CITY OF ALBUQUERQUE

July 6, 2020

Re: Yale Retail
416 Yale Ave SE
60-Day Temporary Certificate of Occupancy
Transportation Development Final Inspection
Engineer's/Architect's Stamp dated 5-16-18 (K16D011)
Certification dated 6-4-20

SHEET NUMBER
TCL-1

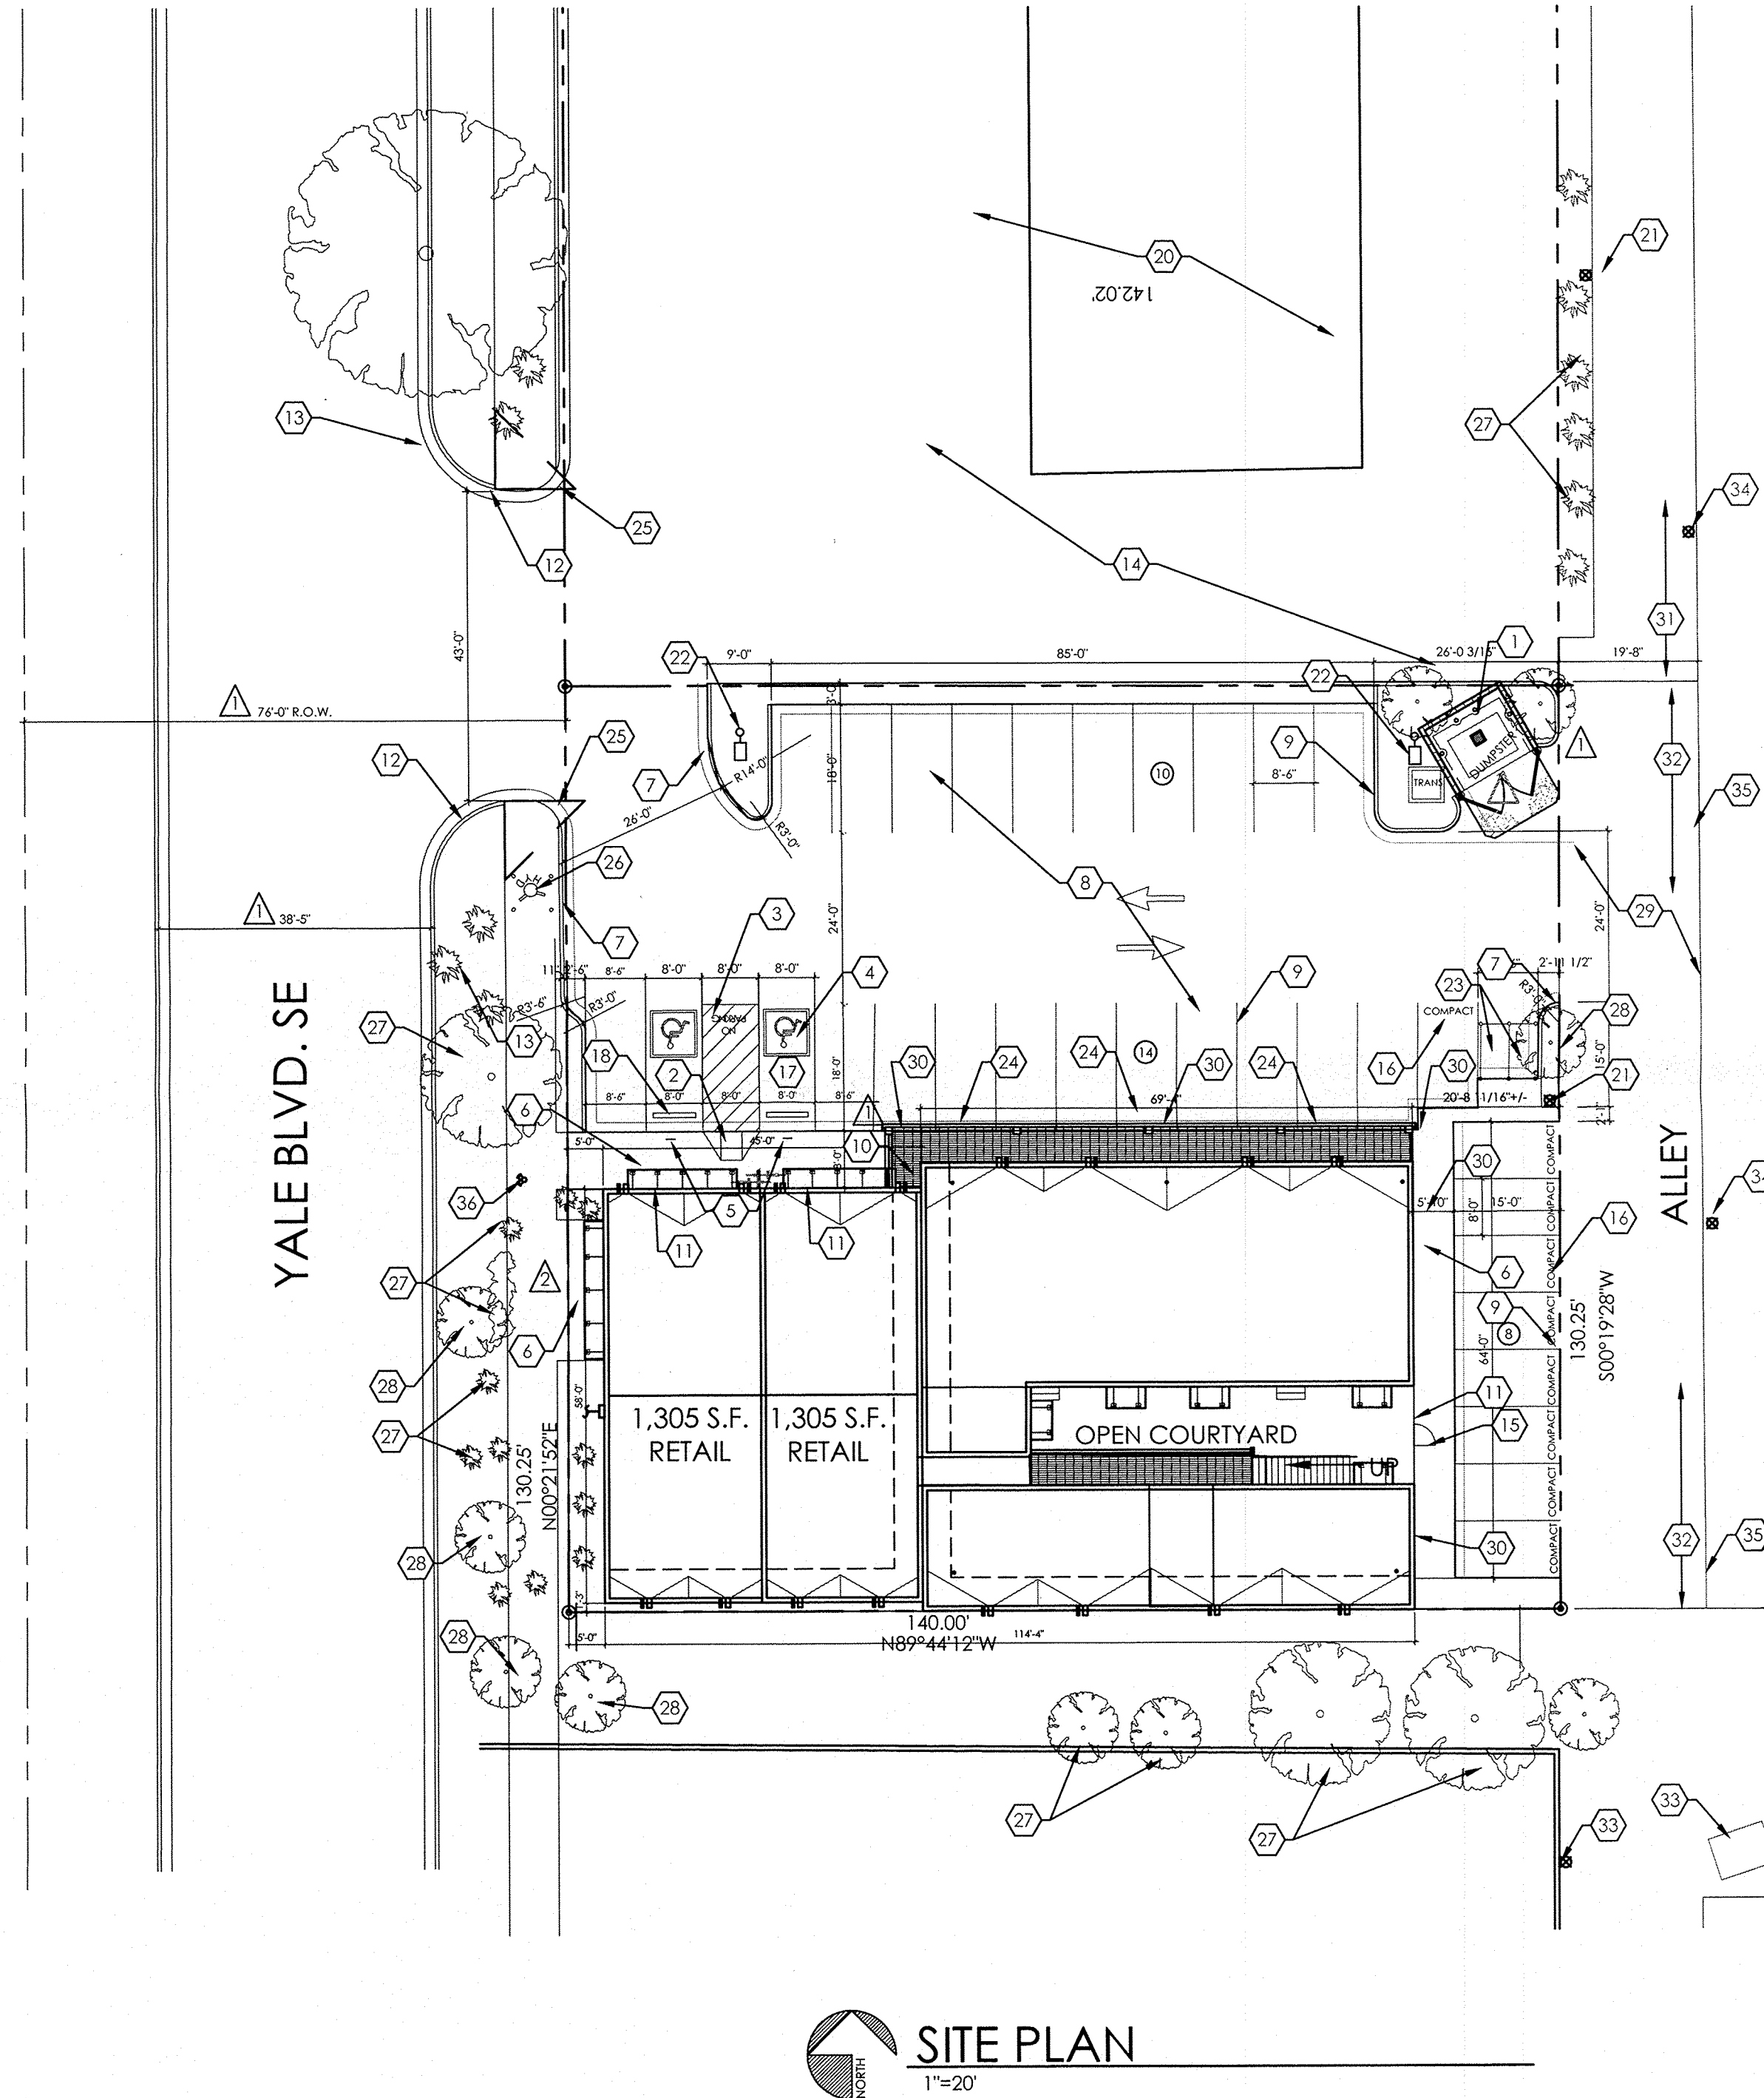
- Alley Paving (Resolution Pending)
- Please correct ADA walk path from public sidewalk to building entrance to meet ADA standards. (Max Running slope 8.0% Max Cross slope 2.0%)
- Please add Traffic rated meter inside parking stall or remove parking stall.

1. Please redline plan to reflect changes to site
Response: See attached site plan with redlines.
2. Bike Rack does not meet city standards.
Response: Owner has modify the site to reflect Bike Rack standards.

3. Update ADA signs to reflect current language and add parking bumpers.
Response: ADA Signs and parking bumpers is been provide
4. Please add work order # Alley Paving.

Response: This requirement has been added to drawings, key note 32 to reflect basecourse .
5. Remove compact from motorcycle stall and stripe for two MC stalls.

Response: Compact is been removed and stripe to reflect two me stalls.
6. Add Concrete Connection from sidewalk to Building entrance for ADA access.
(Maximum running slope 8.0% Max Cross Slope 2.0%) 9.4

Response: Concrete connection had been add to the sidewalk see key note 44.
7. Remove trash container next to compact stall.
Response: trash container is not on our property is on neighbor property

8. Water meter is located within compact parking stalls. Are the meters Traffic Rated? Please contact water Authority.
Response: waiting on water authority for answers.
